Your Ref:
Our Ref: EP/88/08/
Please ask for:
Mr M Porter

3rd July 2008

Change of use from Bank to Indian Tandoori Restaurant (A3)
27 Sea Road East Preston

The Planning Committee of East Preston Parish Council considered this Application at its meeting held on Monday, June 23rd. □

Proposed Front Elevation

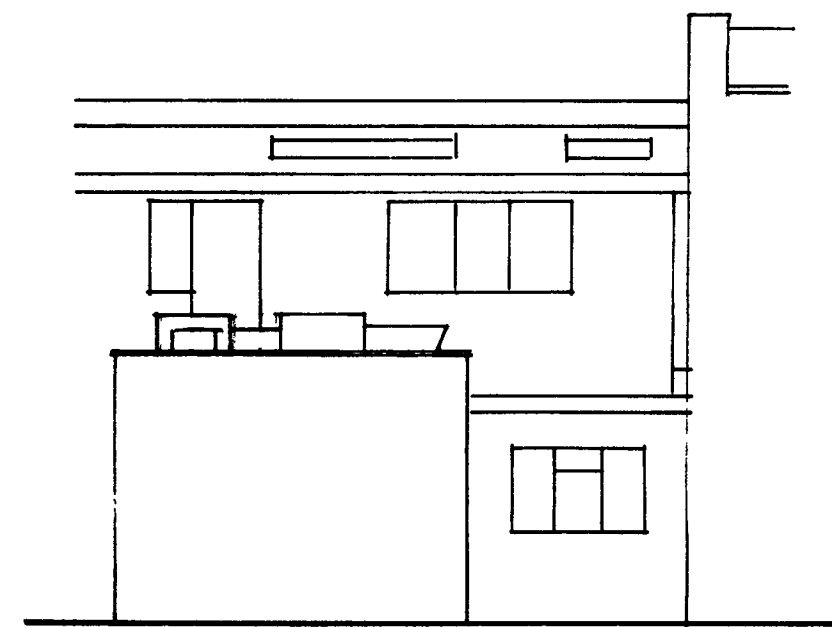
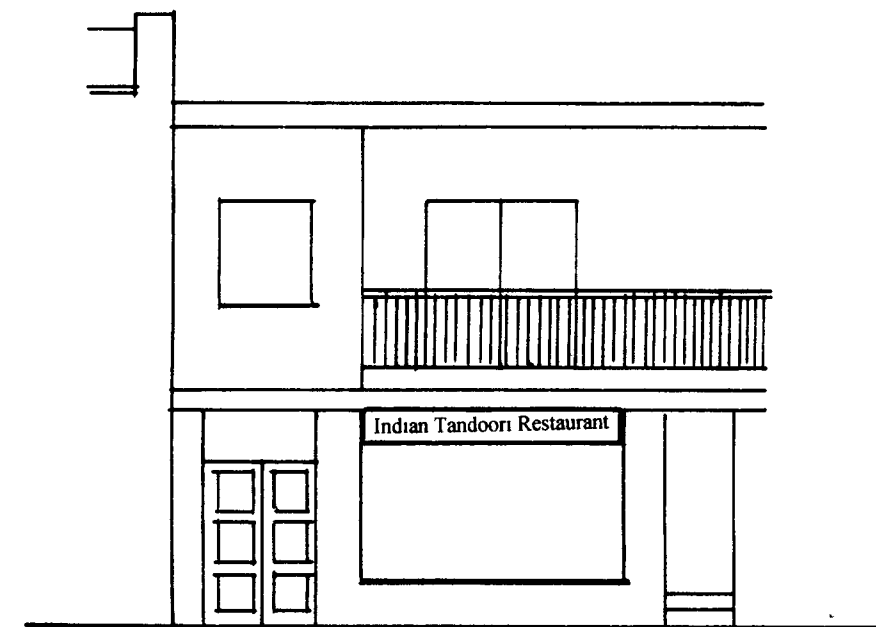
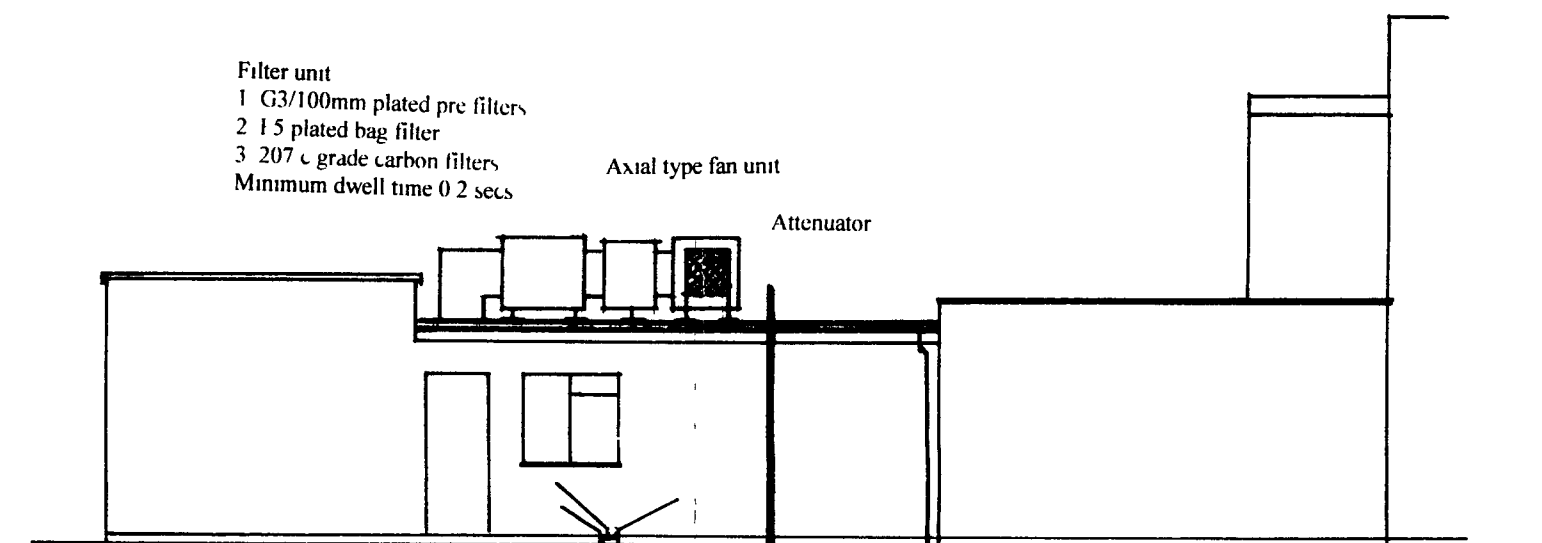
Page 15 of the East Preston Village Design Statement states that 'Shopfronts: should be designed to harmonise with the neighbouring styles and colours. Major changes in style of individual units should be avoided.' The Parish Council is keen to see that this is enforced. □

Block Plan
Scale 1:500

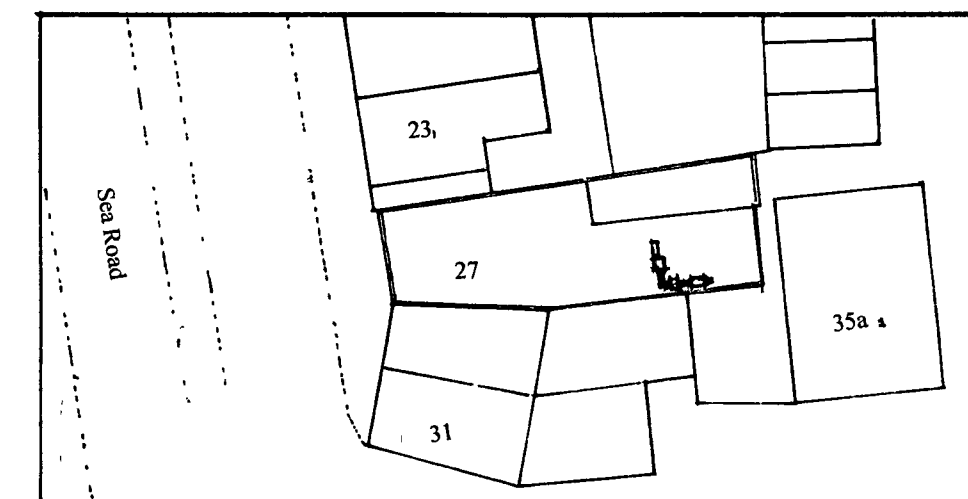
The figures quoted in the Design & Access statement relating to parking are incorrect. By my calculations there are only 31 parking spaces not the 35 quoted, and none are currently designated Disabled. □
